**Yorkshire Water Services  
Developer Services  
Sewerage Technical Team  
PO BOX 52  
Bradford  
BD3 7AY**

**Your Ref: 23/03925/REG3  
Our Ref: A000598**

**26th February 2024**

**Goole Market Hall Estcourt Terrace Goole - Erection of sub-station, switch room, bin store and associated landscaping to existing yard, installation of external extraction units, replacement of roof and installation of rooflights**

<b>PLANNING</b>			
Client: East Riding of Yorkshire Council			
Project Title: Goole Market Hall			
Drawing Name: Proposed -Block Plan			
Drawing No.: GMH-GGA-01-ZZ-DR-A-2100			
Drawn	Project No.	Scale	Rev
SM	145	1 : 200	@A2 P02

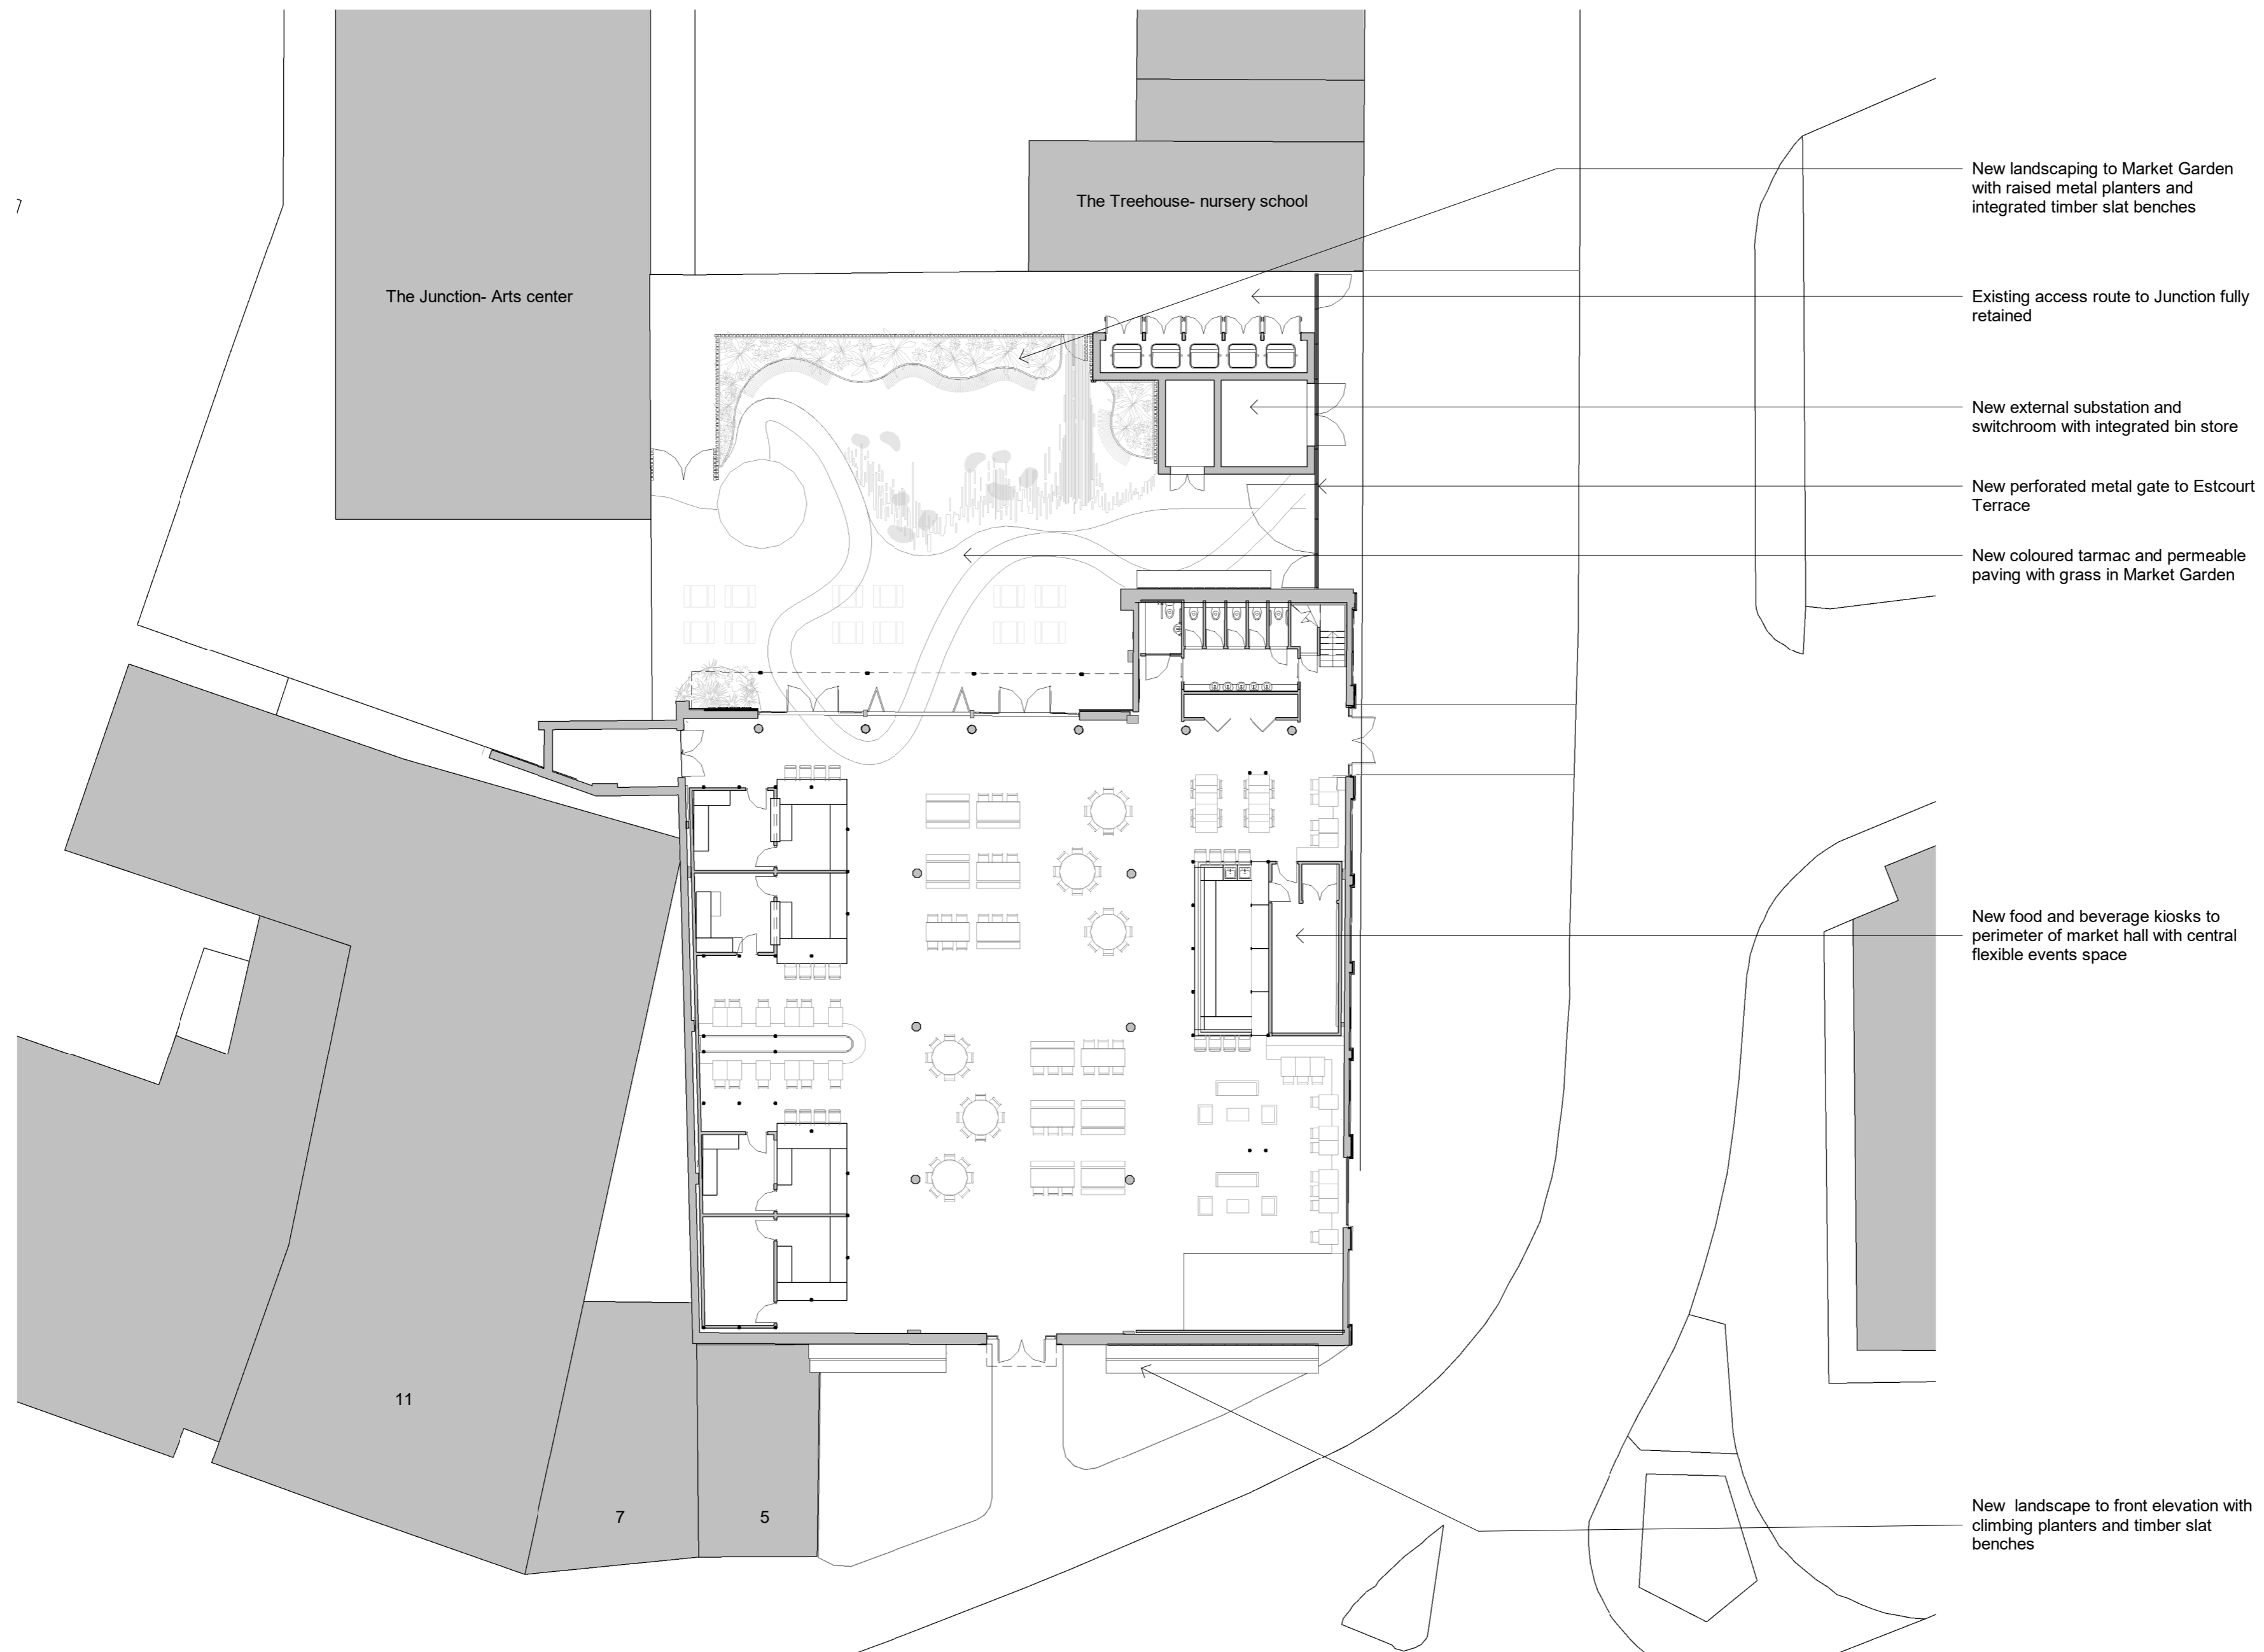
2.) On the Statutory Sewer Map, there is a 1800mm diameter public combined water sewer recorded to cross the site. It is essential that the presence of this infrastructure is taken into account in the design of the scheme.

a.) It may not be acceptable to raise or lower ground levels over the sewer and we will not accept any inspection chambers on the sewer to be built over.

b.) In this instance, a stand-off distance of 5 (five) metres is required at each side of the sewer centre-line and it may not be acceptable to raise or lower ground levels over the sewer, nor to restrict access to the manholes on the sewer.

c.) There should be no new tree planting within 5 metres of this public sewer.

f.) This asset should be adequately protected from loading, vibration and damage from plant and machinery during construction.

**No construction works in the relevant area(s) of the site shall commence until measures to protect the public sewerage infrastructure that is laid within the site boundary have been implemented in full accordance with details that have been submitted to and approved by the Local Planning Authority. The details shall include but not be exclusive to the means of ensuring that access to the pipe for the purposes of repair and maintenance by the statutory undertaker shall be retained at all times.**
